**Transport
for NSW**

**Section 75W Modification Application (MP08_0241 MOD 5)
86-96 and 100 Mount Street, North Sydney**

TfNSW has reviewed the supporting documentation and comments are provided in relation to Railway Infrastructure Contribution, Active Transport and Construction Traffic Management at **TAB A** for consideration in the assessment of the application and in drafting of conditions.

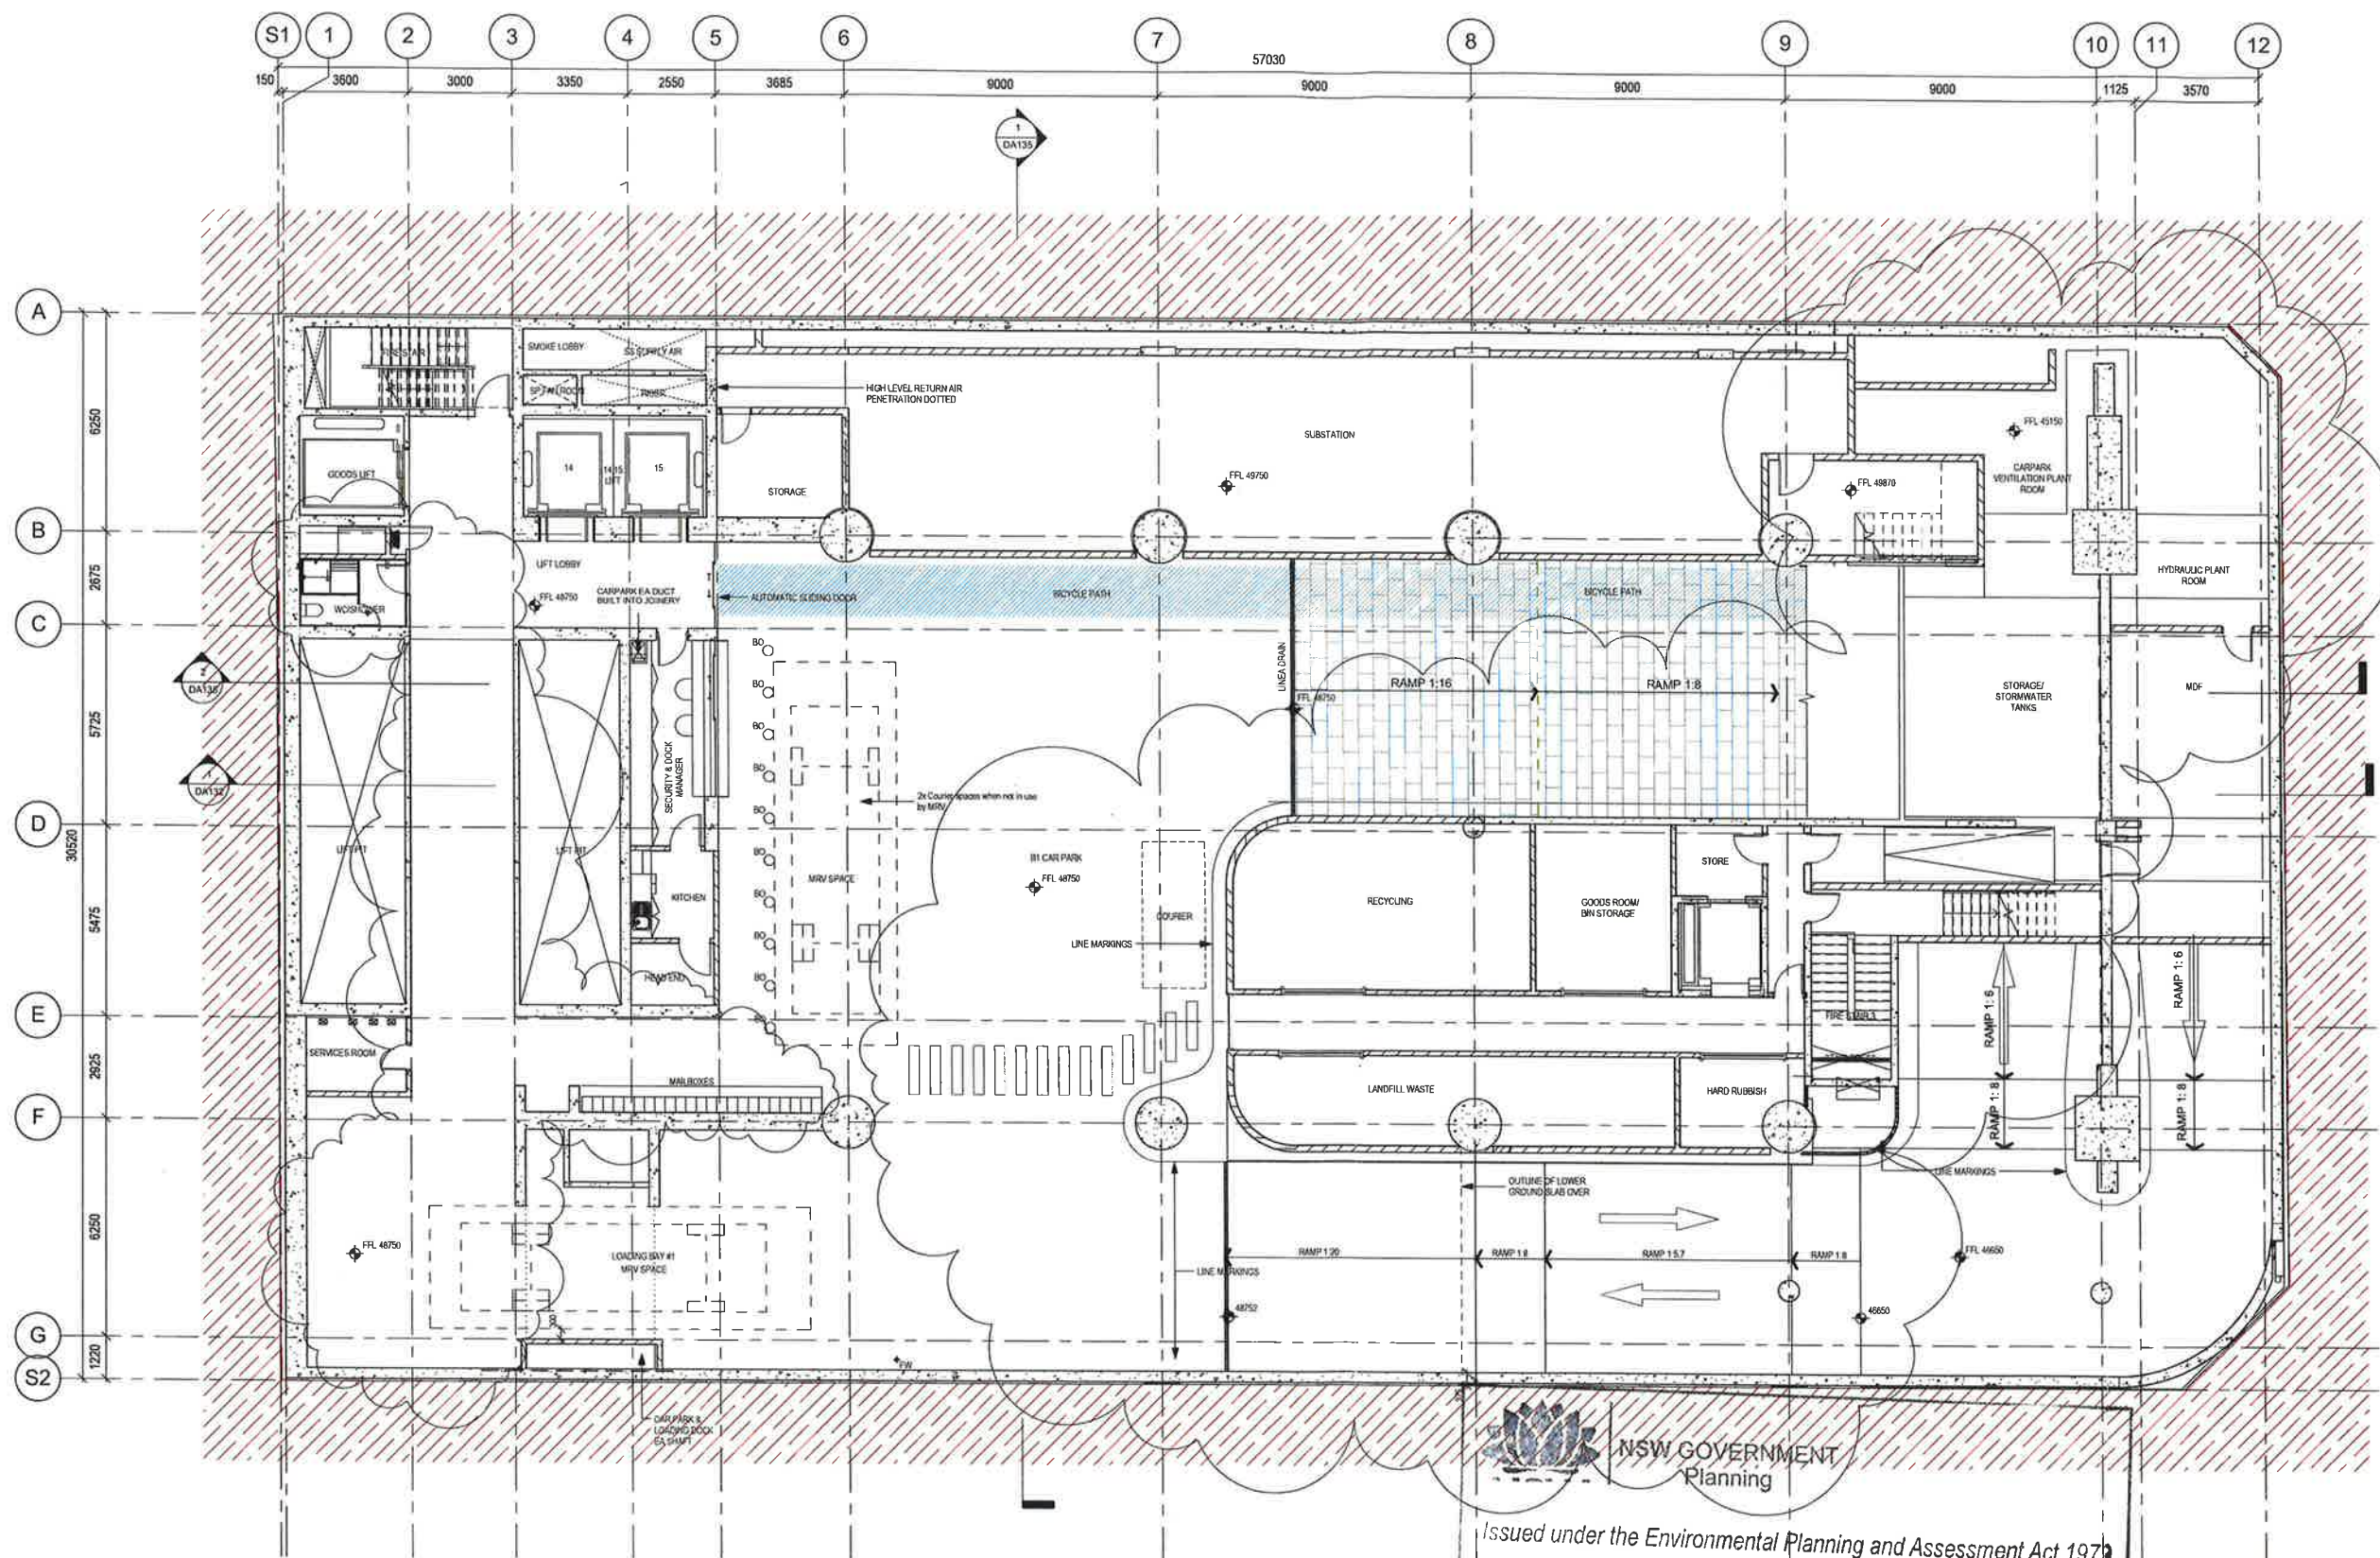
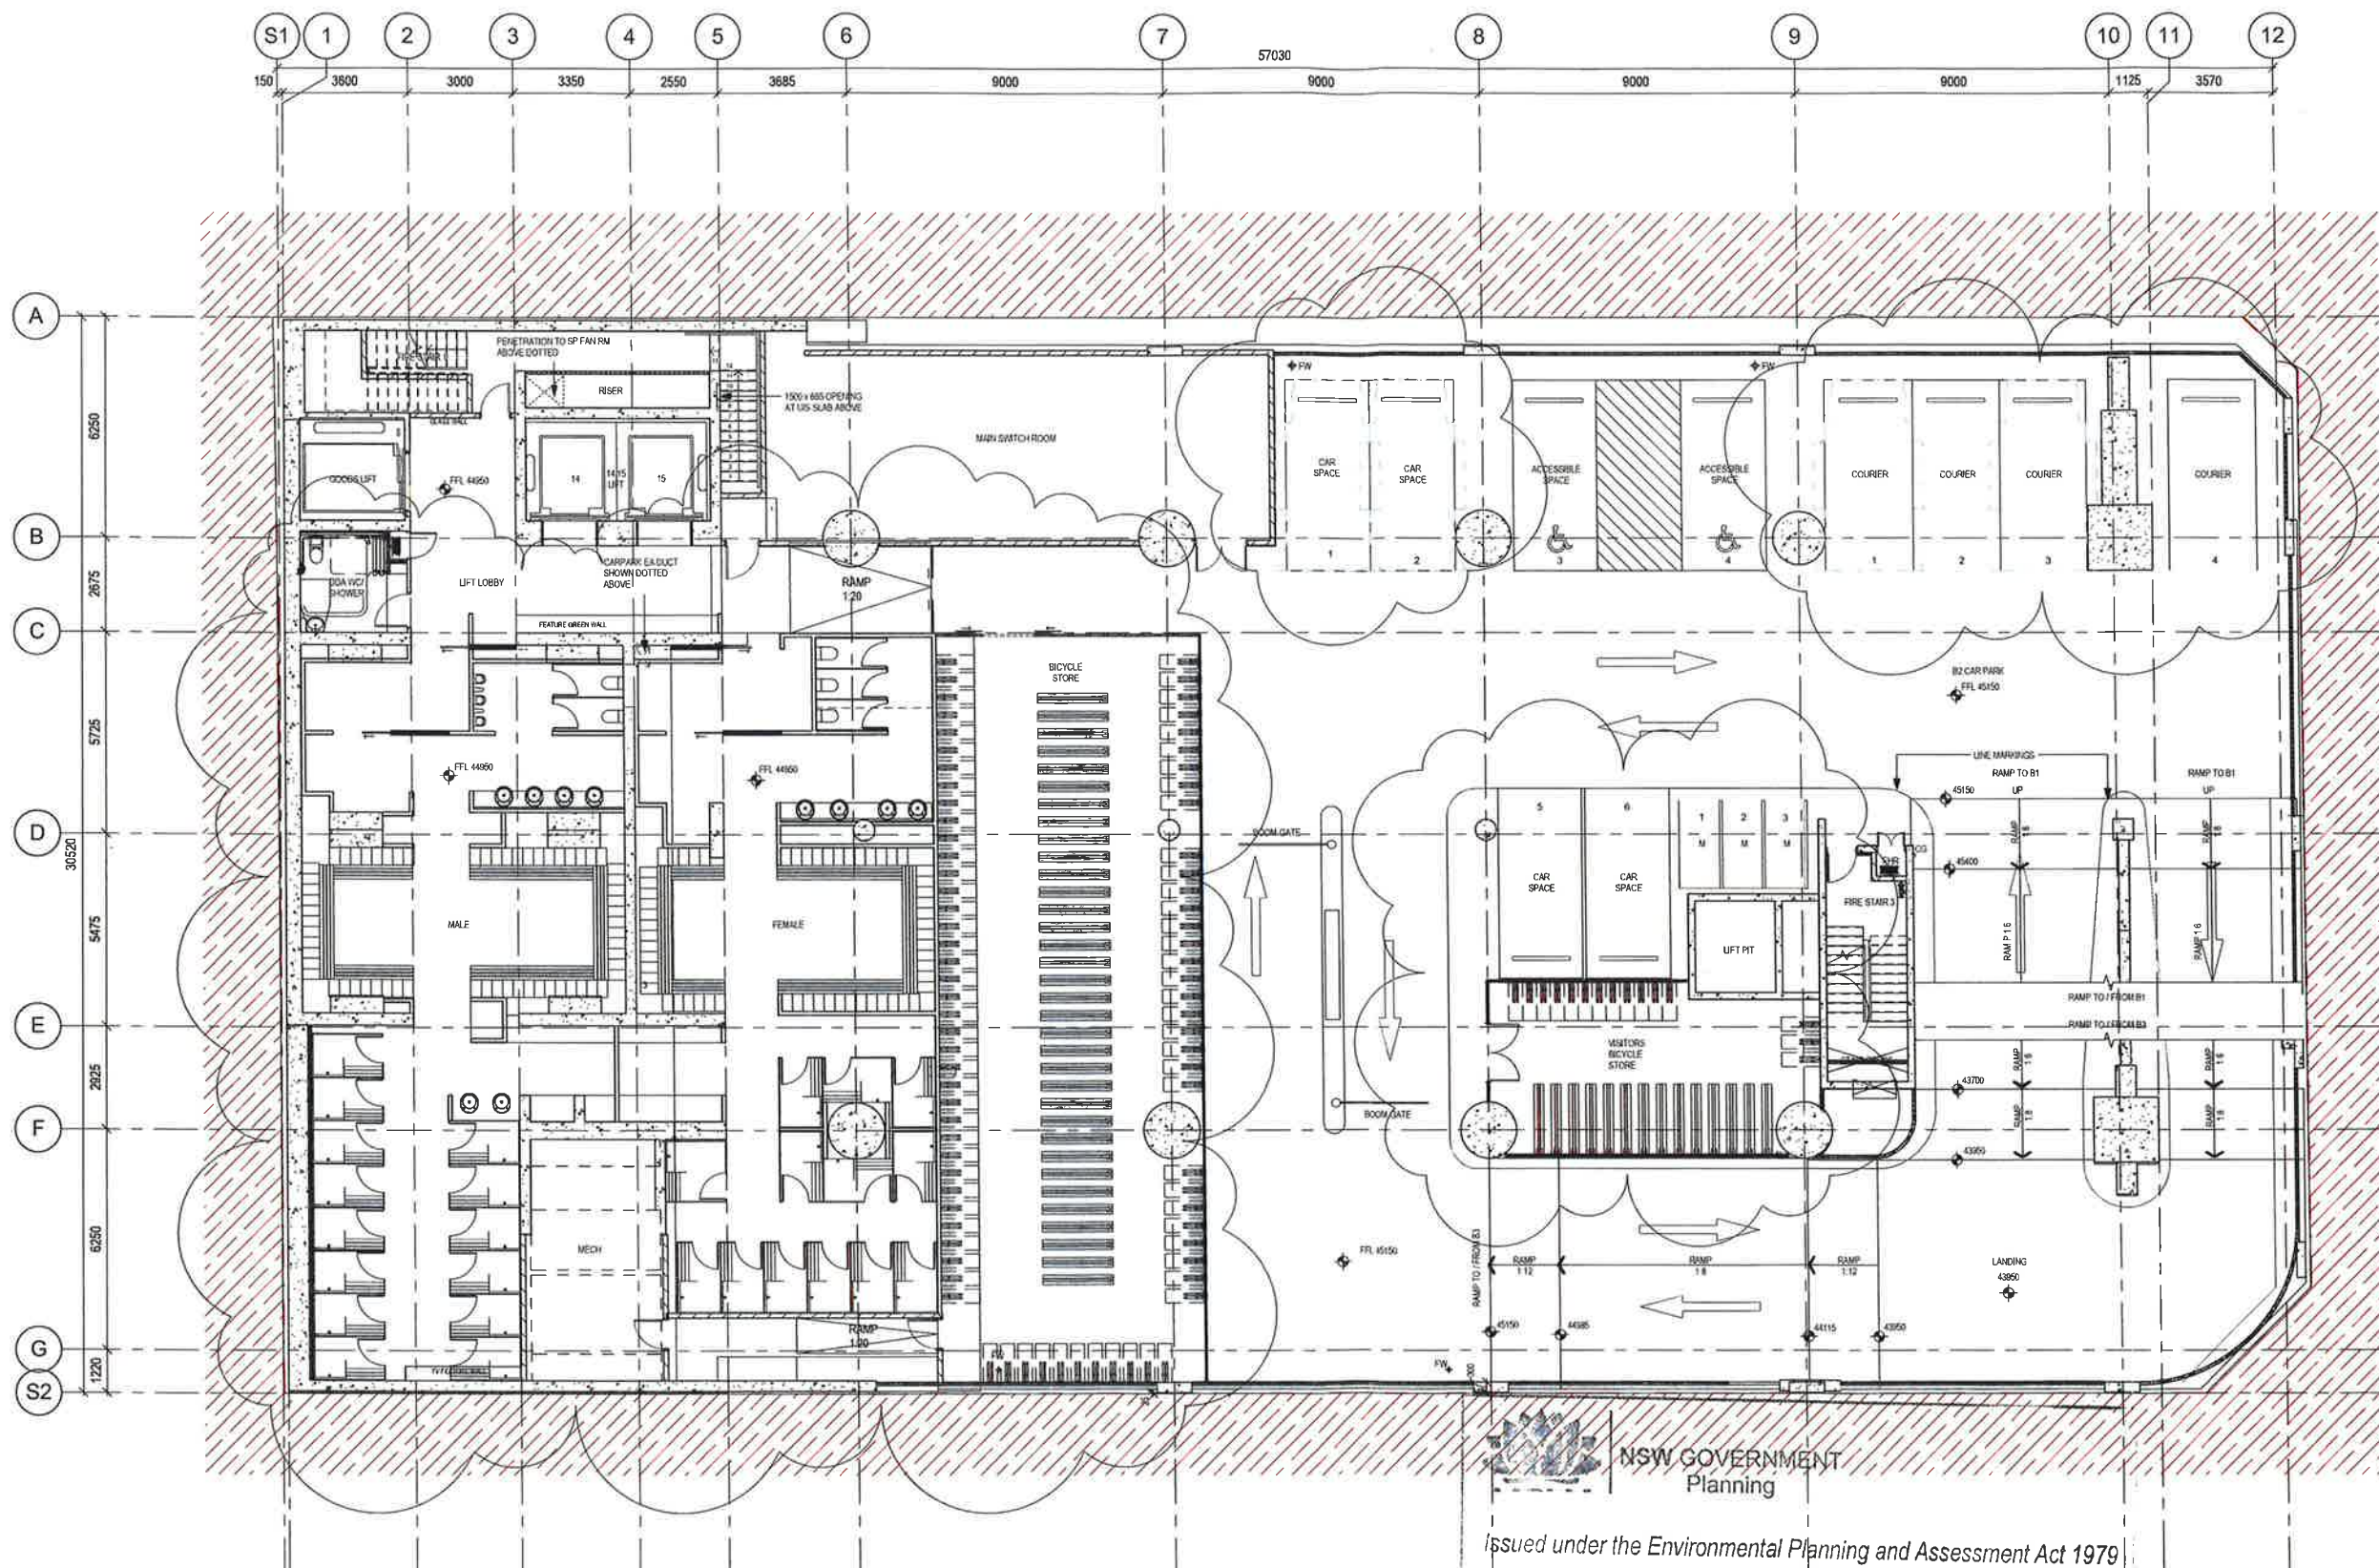
The proposal results in a loss of 96 bicycle parking spaces. Bicycle parking should be provided in accordance with North Sydney DCP requirements.
